Comment for planning application 23/00376/F

Application Number	<input type="text" value="23/00376/F"/>
Location	<input type="text" value="Land Adjoining And West Of Stonecroft House Clifton Road Deddington"/>
Proposal	<input type="text" value="Erection of 5 single storey age restricted dwellings for older people (60 years) with access, landscaping and associated infrastructure"/>
Case Officer	<input type="text" value="Imogen Hopkin"/>
Organisation Name	<input type="text" value=""/>
Name	<input type="text" value="Luke Hoyer Millar"/>
Address	<input type="text" value="Castle End House, Castle Street, Deddington, Banbury, OX15 0TE"/>
Type of Comment	<input type="text" value="Objection"/>
Type	<input type="text" value="neighbour"/>
Comments	<input a="" also="" and="" any="" at="" be="" believe="" can="" condition="" development?<br="" dry="" end="" england's="" existing="" following="" historic="" i="" match="" new="" of="" recommendation"="" repair="" southern="" stone="" stonewall.="" the="" this="" to="" type="text" value="Apologies

Plot 3  
Ground Floor Plan

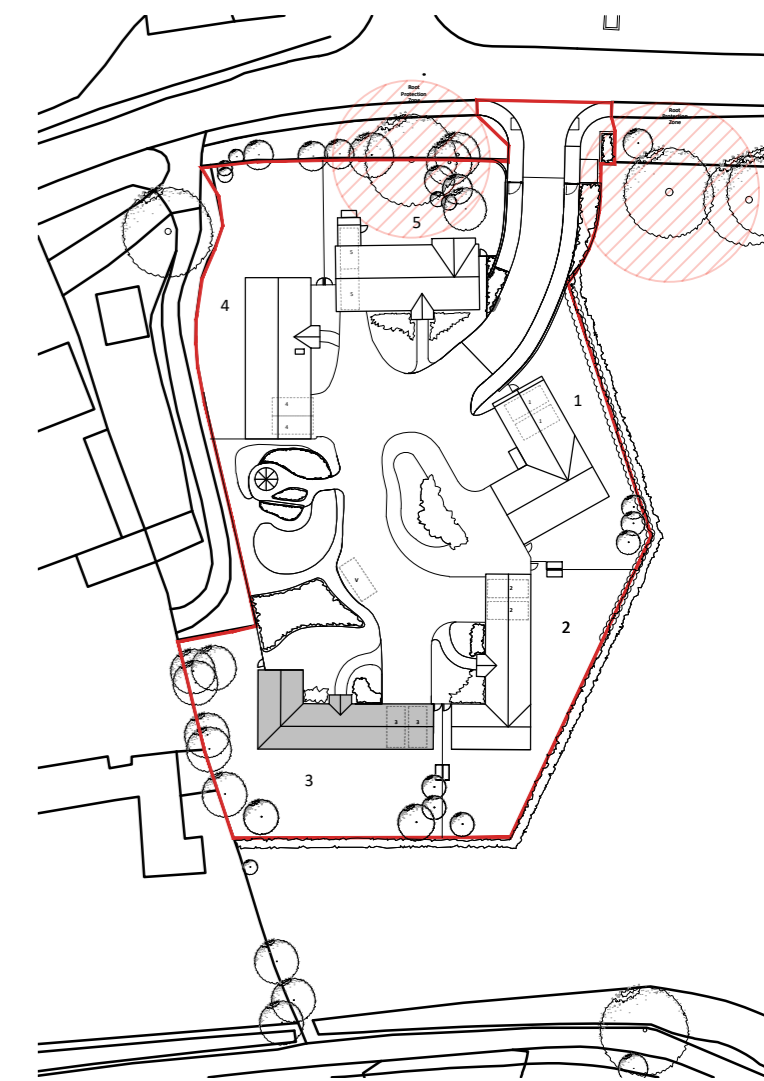
A couple of further thoughts:
I notice that it is proposed that plots 2&3 (most visible from the Castle Grounds and partially from Castle End House) are to be made of red brick. Is this really an appropriate material here. Marlstone and timber as elsewhere in the development would seem more appropriate. I'm glad to see that the developer still intends to provide " wall=""/> Thanks"/>
Received Date	<input type="text" value="19/10/2023 10:22:38"/>
Attachments
